Your reference SSD-6026
Our reference: DOC13/77662
Our contact: Rebecca Whiteside, ph: 9995 6846

Attachment 1: EPA comments on the EIS for Milk Processing Facility, Erskine Park SSD-6026

DRAWING TITLE	BULK EARTHWORKS DRAINAGE STRATEGY
DATUMS:	AHD / MGA PLANE
CLIENT No.	C201
DRAWING No.	ML13007-C201
REVISION	p3
Aug. 27, 13 - 11:57:20 Name: ML13007-C201.dwg Updated By: Patrick Daly

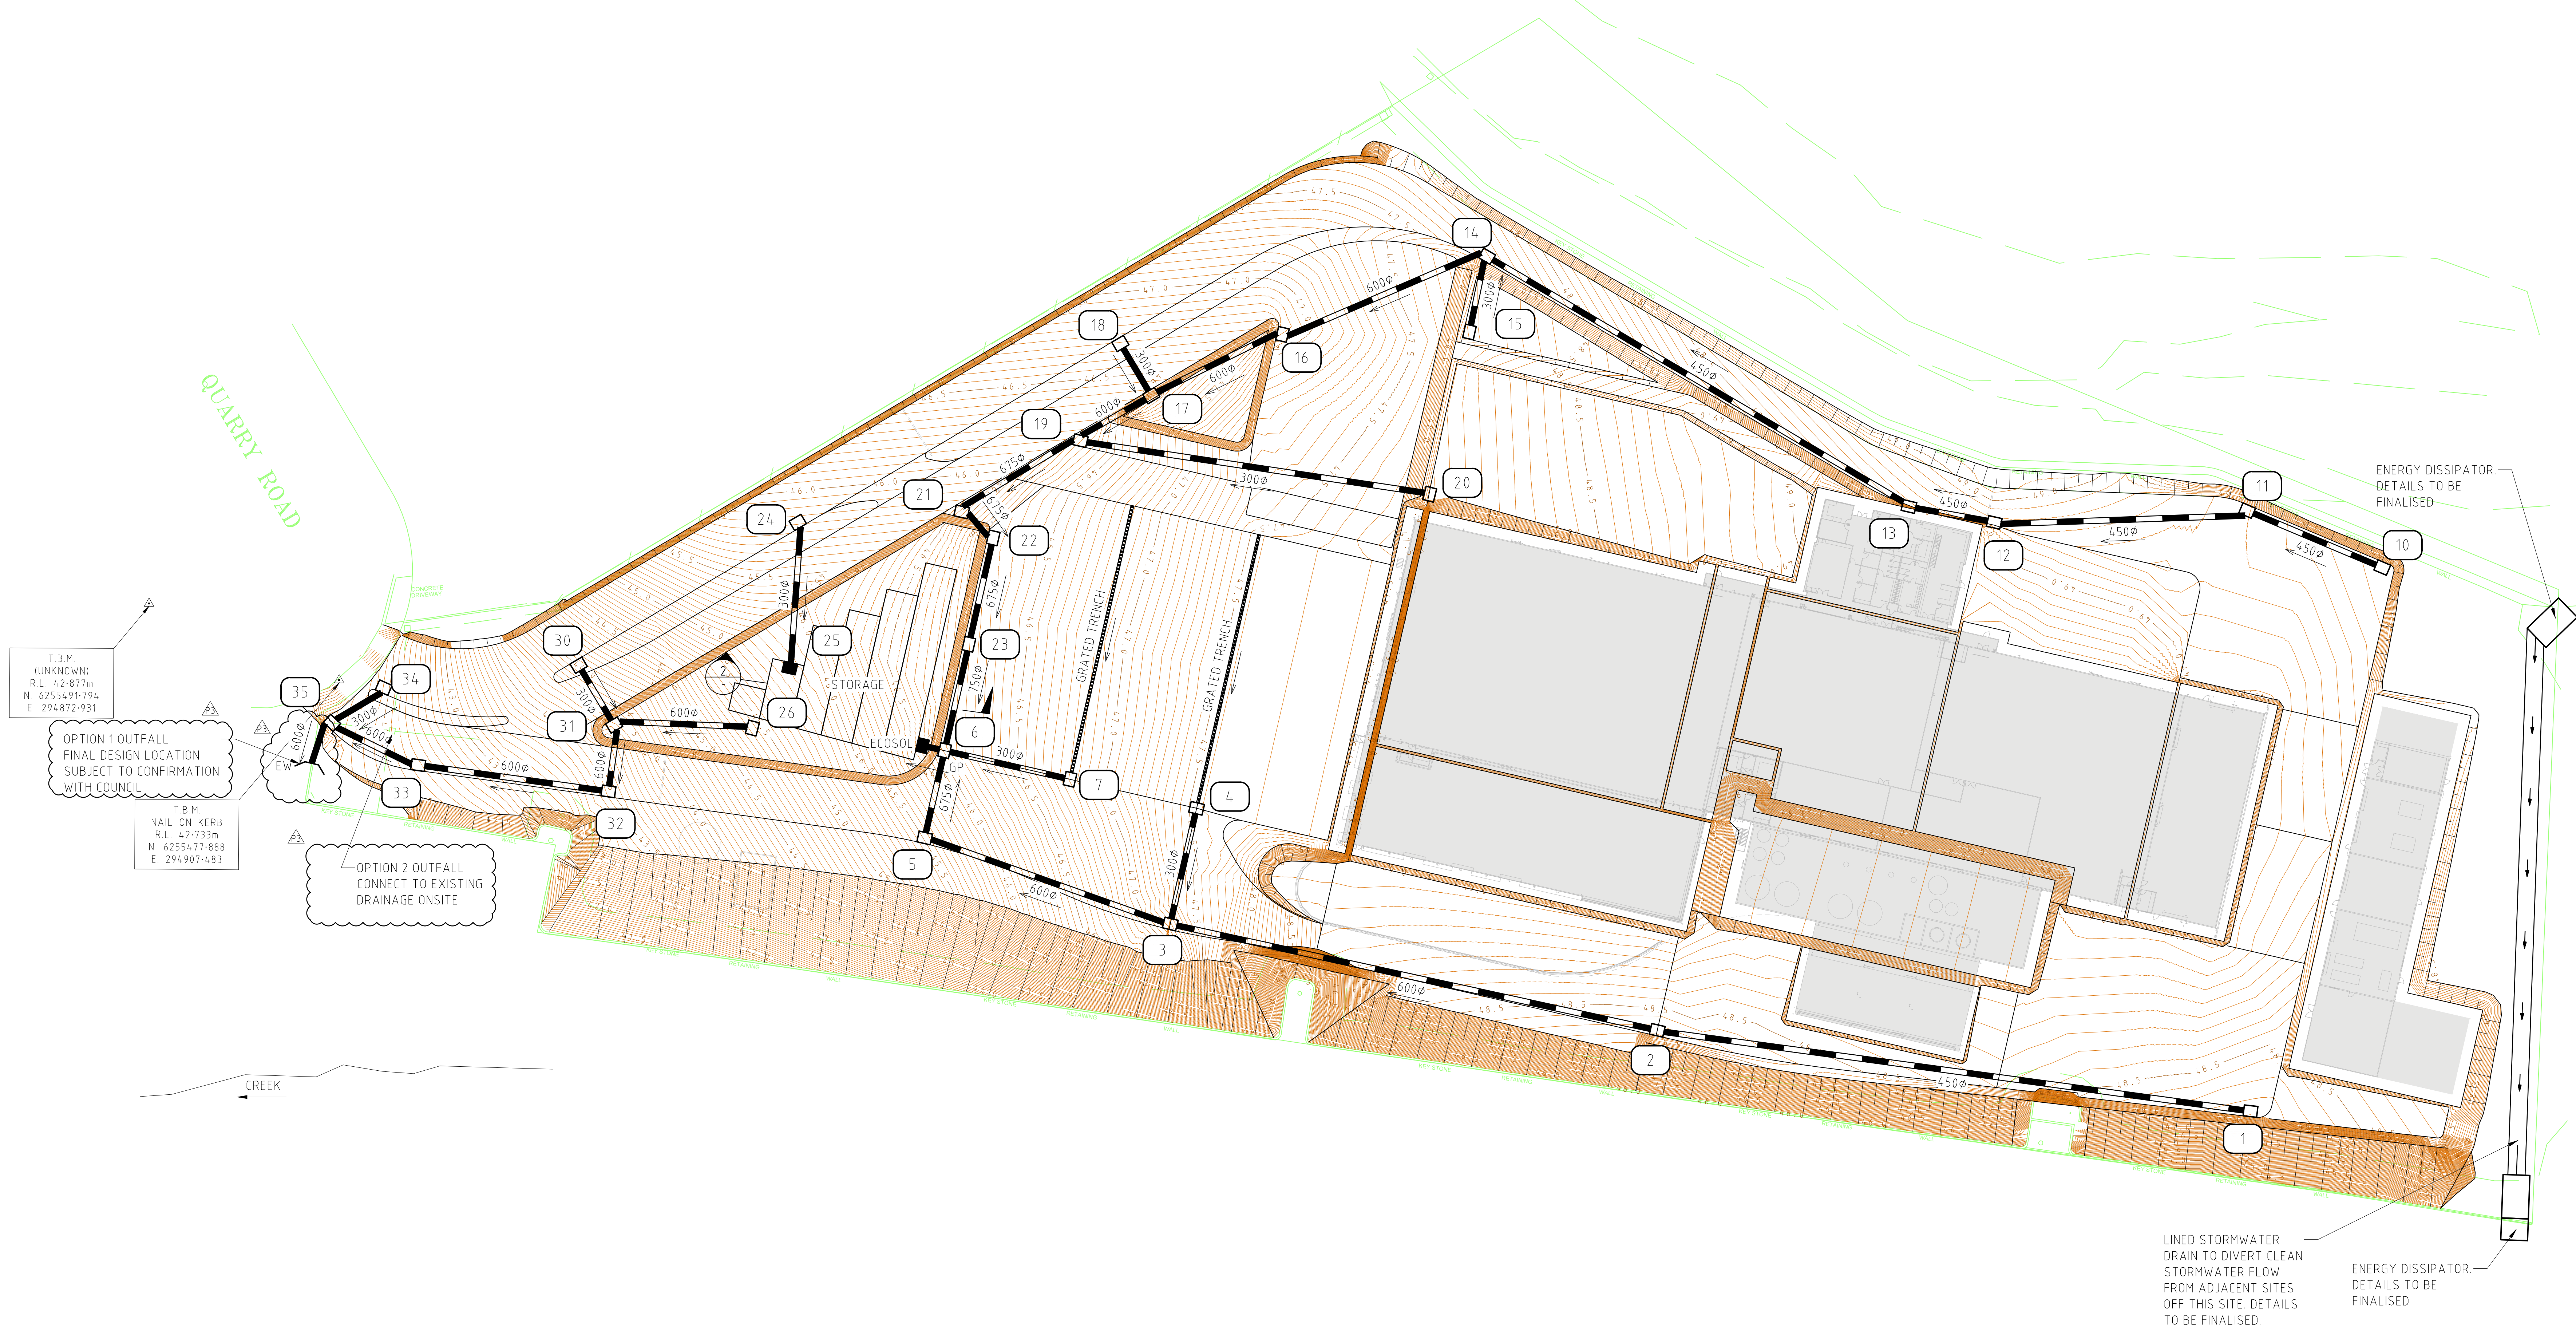
The document titled: *Stormwater Management Strategy: Inverloch Site in Erskine Park, Sydney* prepared by Pitt&Sherry dated July 2013 for the proposal identifies the tank farm as one area where there is a high risk of spillage.

The EIS indicates that the tank farm will be bunded (but not covered) and that under normal conditions will drain to the stormwater system which has a sensor in place should an incident occur which will shut the outfall to the stormwater system and divert dirty stormwater / spillage to the trade waste system.

The EPA is concerned that the proposed controls within the tank farm may result in the pollution of waters as prescribed under section 120 of the POEO Act. Once licensed, the EPA will be interested in gaining a better understanding of both the facility's tank farm and the operation of the stormwater system.
